Please ask for: Mrs D Johnson
Email: daun.johnson@arun.gov.uk
Telephone: 01903 737762
Our Ref: BR/243/20/L
Your Ref:
Date: 14th October 2020

Listed Building Consent for Alterations, Extension or Demolition of a Listed Building

Development: Listed building consent for an access ramp.
Location: 51 Canada Grove Bognor Regis PO21 1DW

No.	Description	Date
Client: Bognor Town Council		
Address: 51 Canada Grove, Bognor Regis, PO21 1DW		
Project: Disabled Access Ramp		
Drawing title: Block Plan		
Project No		SSE_194
Date		15-10-20
Drawn by		IA
Drawing No		BP01
Scale1:500@A3

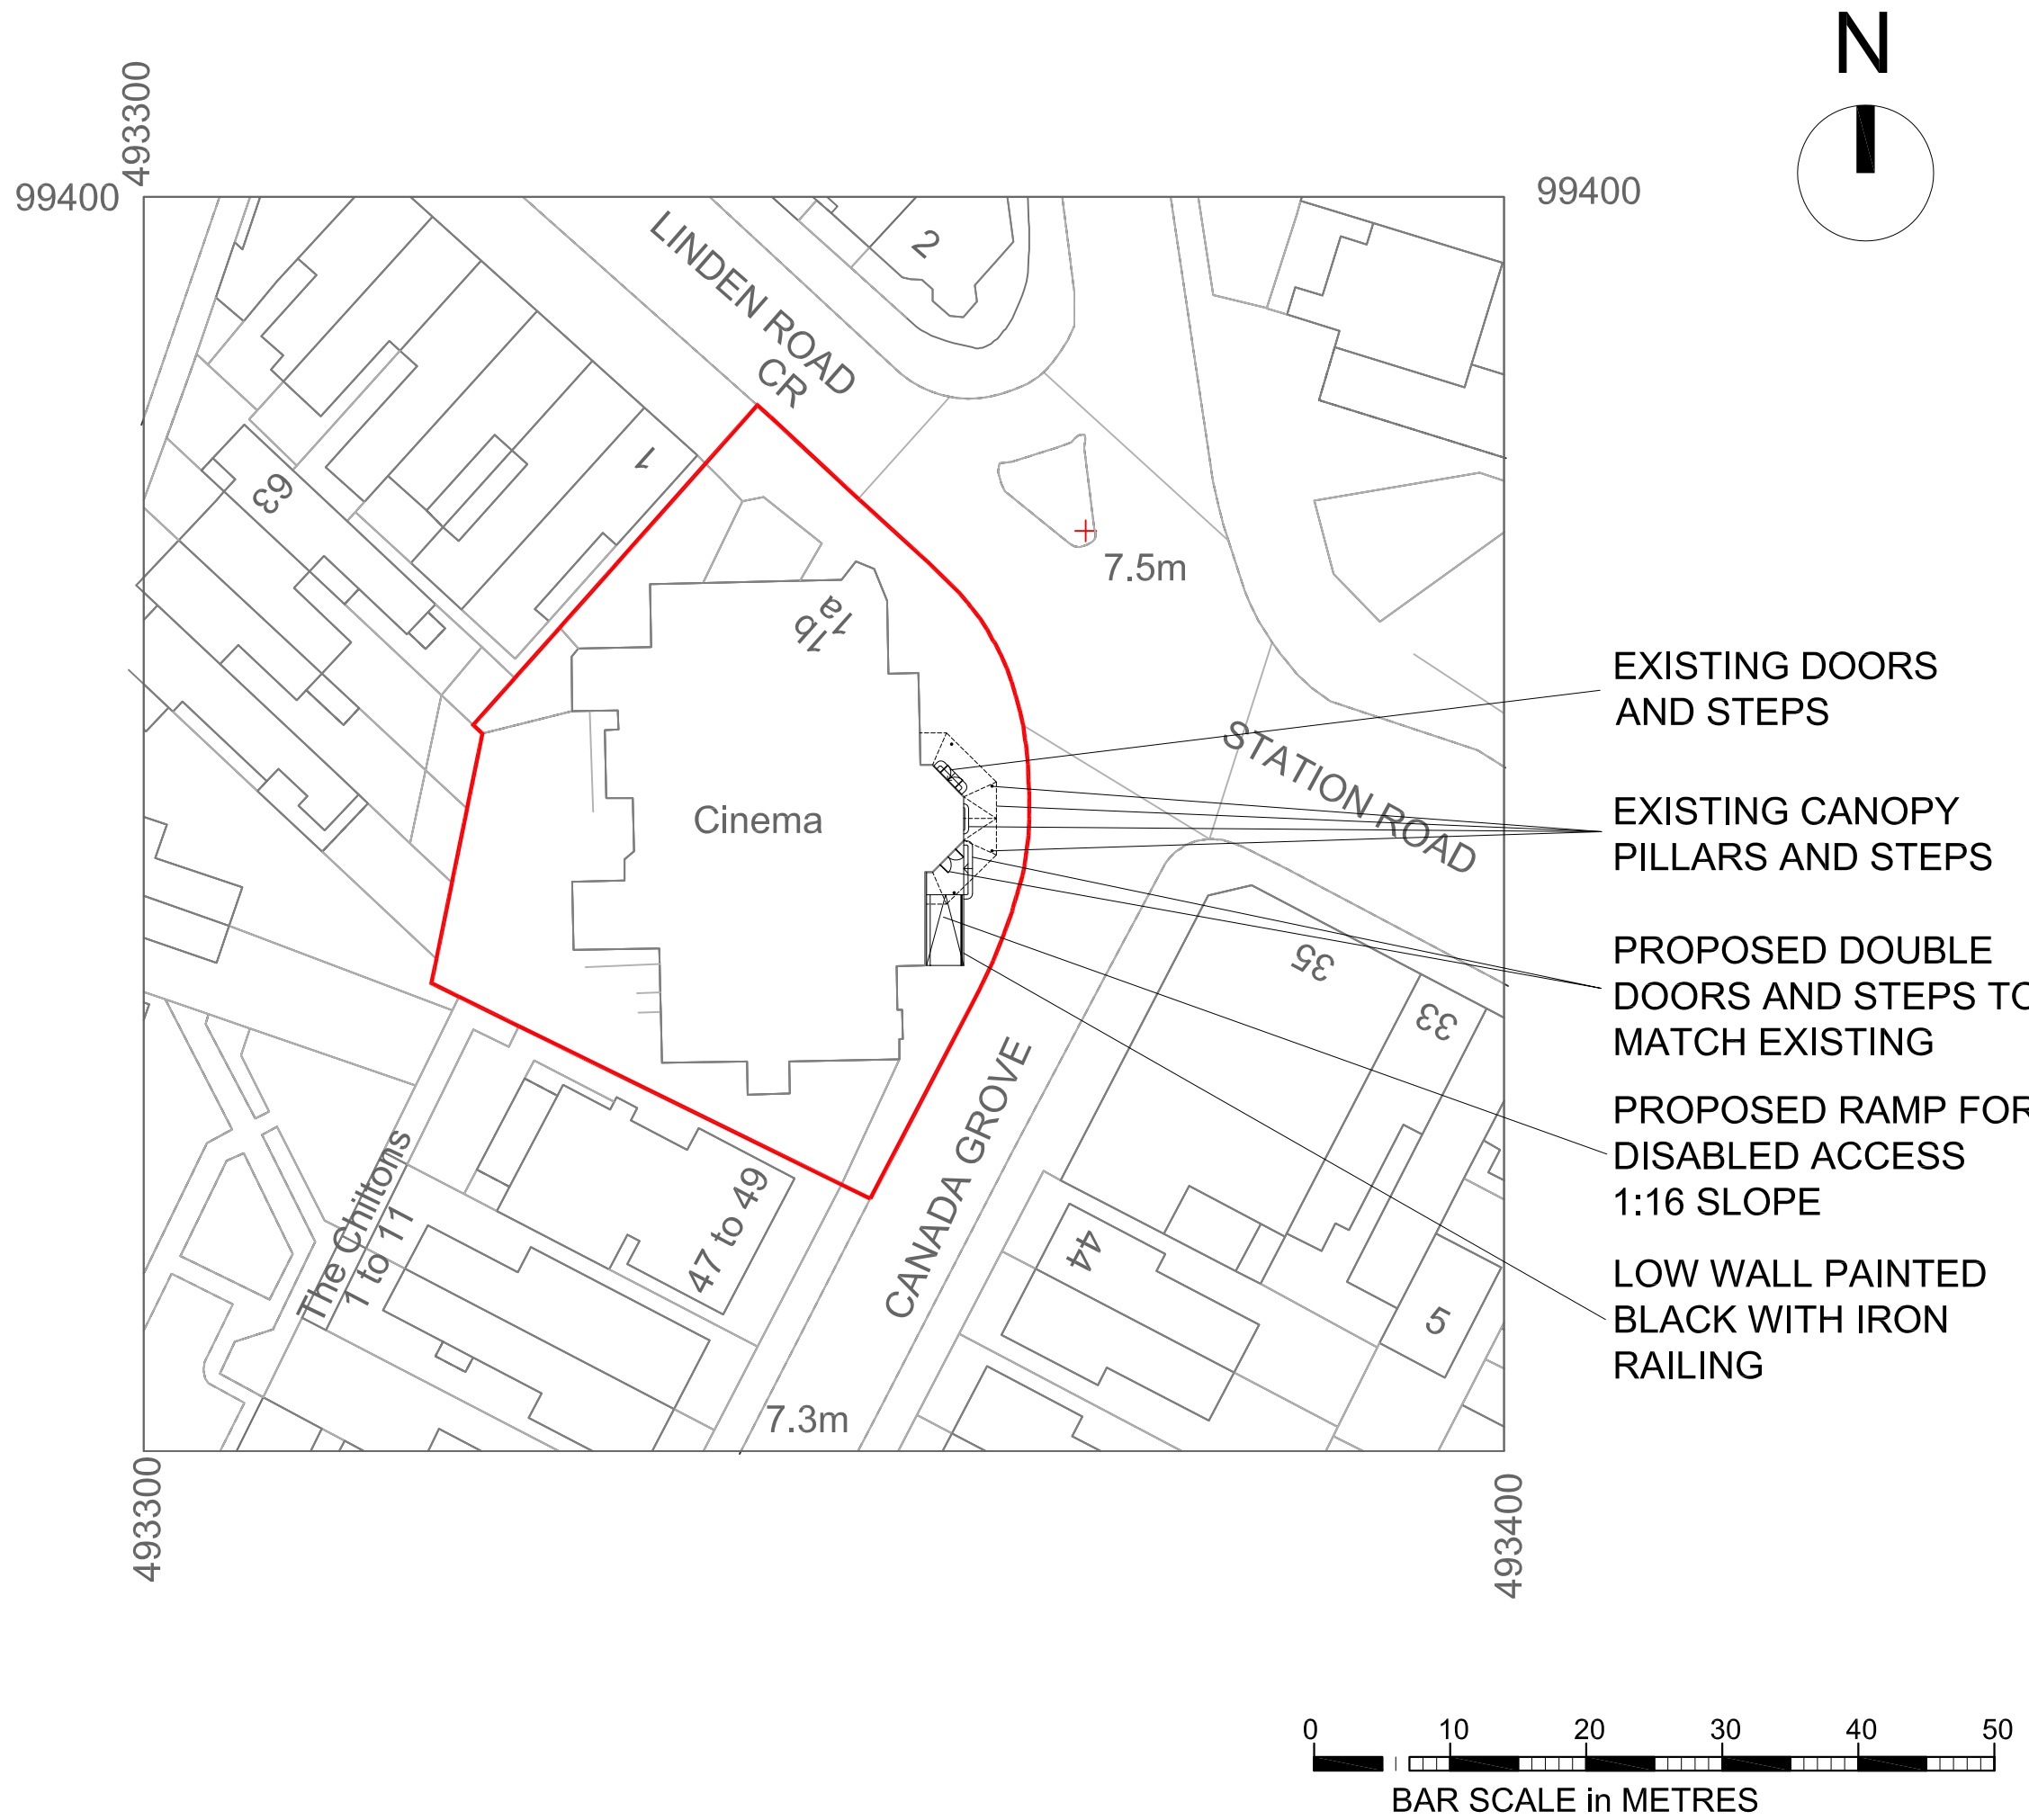
Block Plan

Please provide a North point.
Schedule of Works
